**WELWYN HATFIELD BOROUGH COUNCIL
EXECUTIVE DIRECTOR - PLANNING, PUBLIC PROTECTION AND GOVERNANCE**

DELEGATED APPLICATION

Application No: 6/2020/0009/HOUSE
Location: Bell Bar Pet Farm, Bell Lane, Brookmans Park, Hatfield, AL9 7AY
Proposal: Erection of two storey front extension, single storey side extension, 3no rear dormers, raising of ridge height and insertion of rooflights
Officer: Mr David Elmore

Recommendation: Granted

Proposed Front Elevation (North)  
Scale 1:100

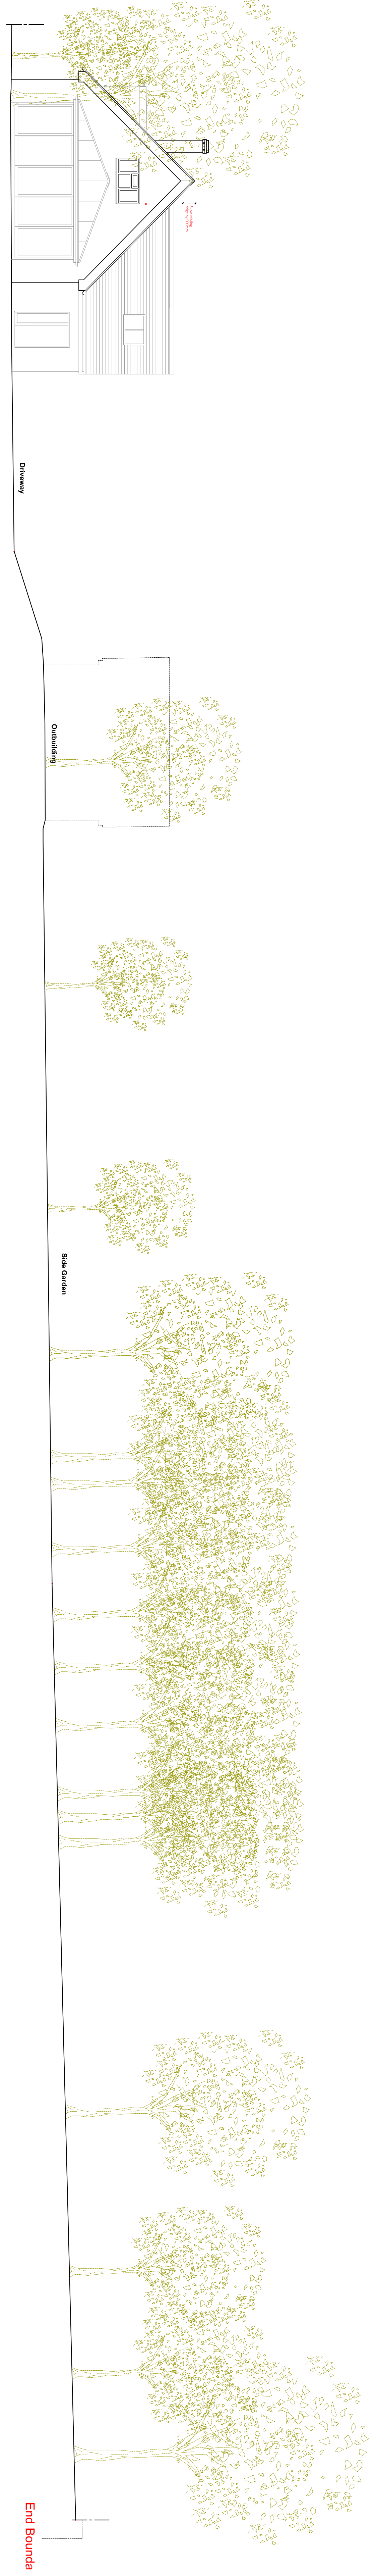
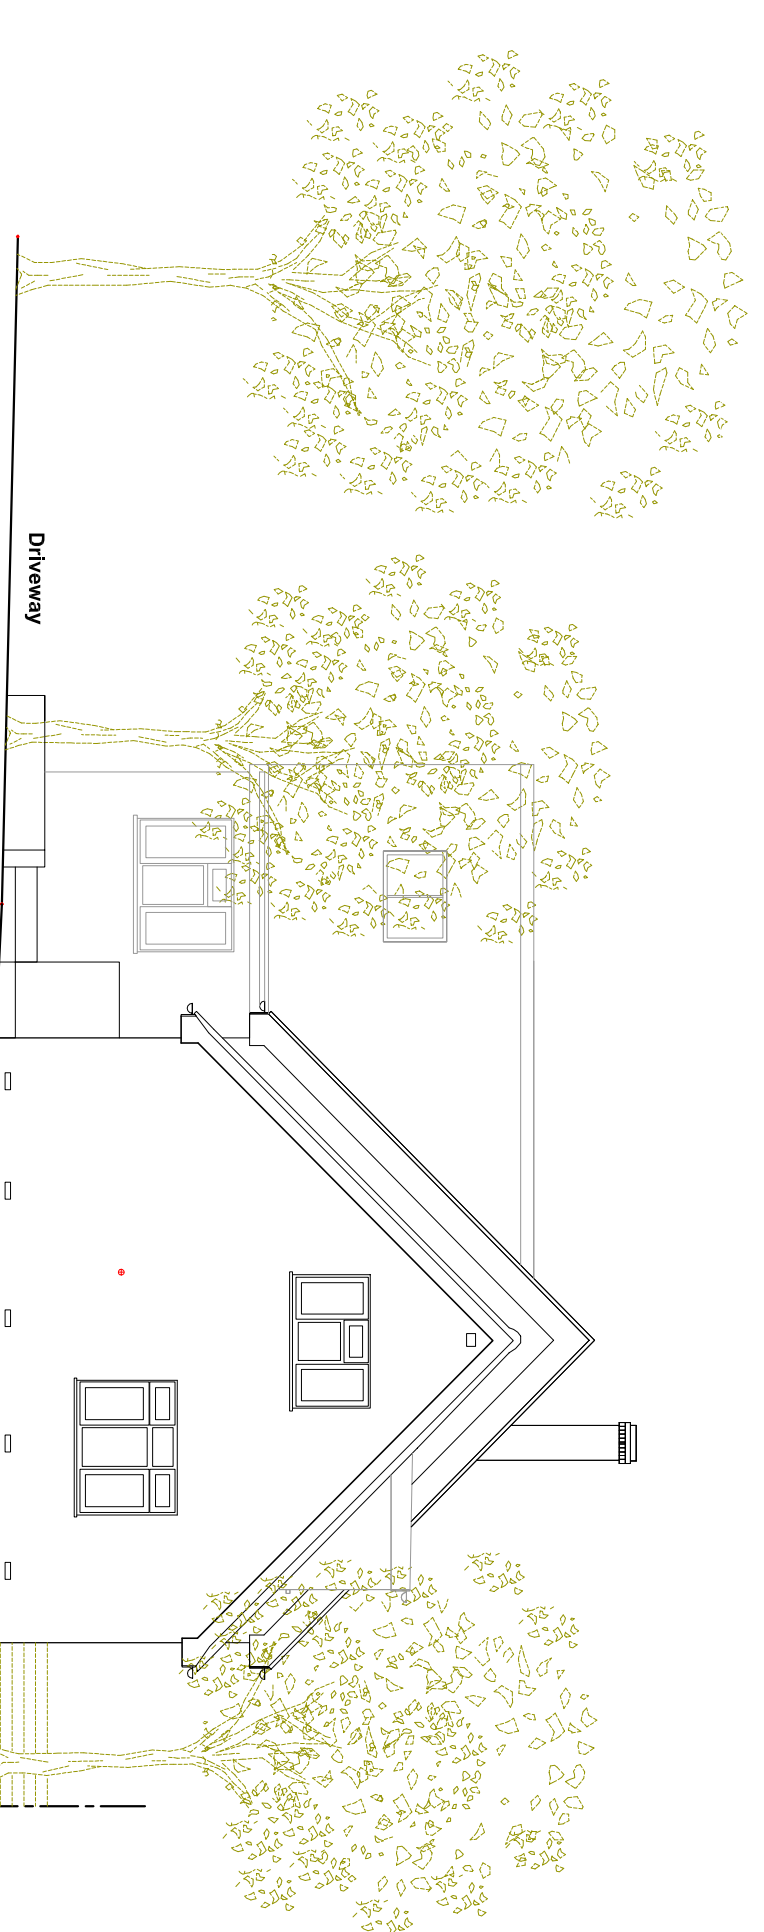
Visually, the extensions would sit comfortably alongside the original building, would not dominate the original building, nor would they fundamentally alter its character or appearance. In terms of a qualitative assessment of the proposal in the context of the size and character of the original dwelling and its surroundings, the development is subordinate to the design and scale of the host dwelling.

1. The brickwork, roof tile, bond, mortar, windows, detailing, guttering, soffits and other external decorations of the approved development must match the existing dwelling in relation to colour and texture.
